Topic Header	Issue number	Page number (officer's report – 2022/92169) or original pre-application response	Issue	Action to Resolve
Pre-app advice not taken on board	1	4	Officers would also note that pre-application advice has been provided in relation to residential development at the site, but it appears that the advice provided by Officers has not been adequately taken on board.	All issues raised in the officer's report and <i>previous</i> ++ pre-app response have been addressed within this document. ++ i.e. in connection with previous unsuccessful proposals.
Green Belt	2	9	Two storey side extension to the gable end of the attached barn does not appear as a proportionate addition to the barn. (Contrary to national / local policy).	The proposed two storey extension has been retained for the architectural reasons set out at Point 11 below. It has been reduced in depth and width to take on board previous comments. When considered as an extension to the attached and detached barns (because they will be linked), the extensions are not disproportionate to the original structures: Volume existing attached and detached barns: 497 + 218 = 715 cu.m. Volume of extensions: 270 cu.m $270/715

typical external barn screen elevation
the barn unit
scale 1:20

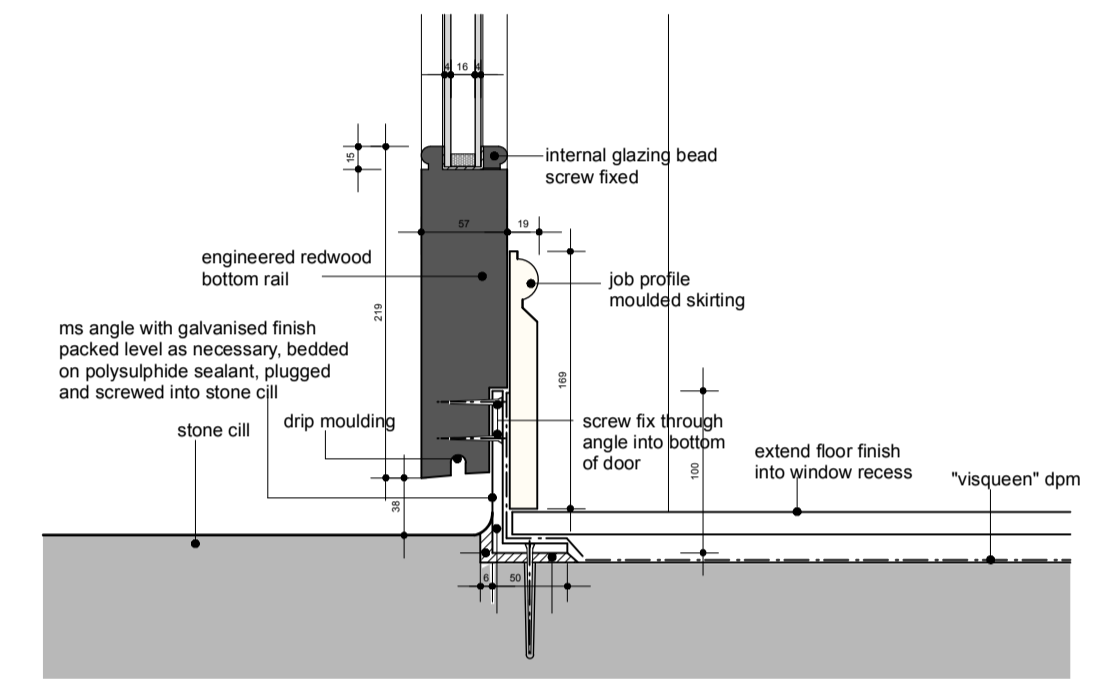
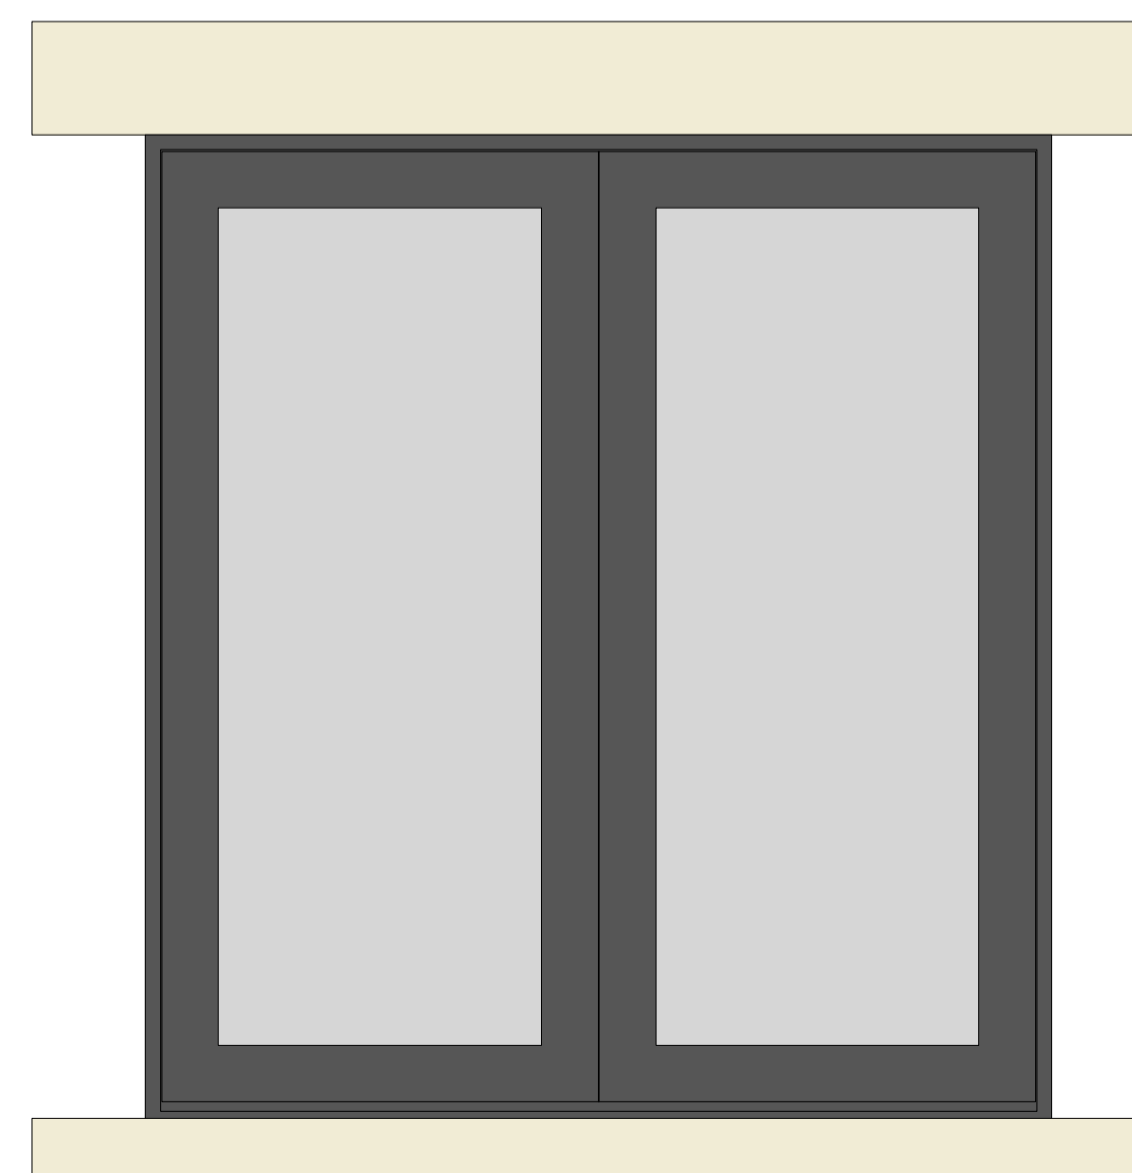
Heritage	13	16	Barn conversion – “In terms of external alterations, a large fixed window is proposed in place of the existing inward opening timber doors in the arched entrance of the attached barn. This alteration is not considered to reflect the historic character of the site and whilst some level of glazing may be acceptable, this should be set back towards the inner edge of the opening to distinguish it from the windows and reveal the stonework. The arched head window above, also shows a timber framed arched window without infill panel....	As above - glazing to barn arches as simple clear glass screens, with only single divisions at most. Minimal, single pane new openings and more agricultural and in keeping in character.
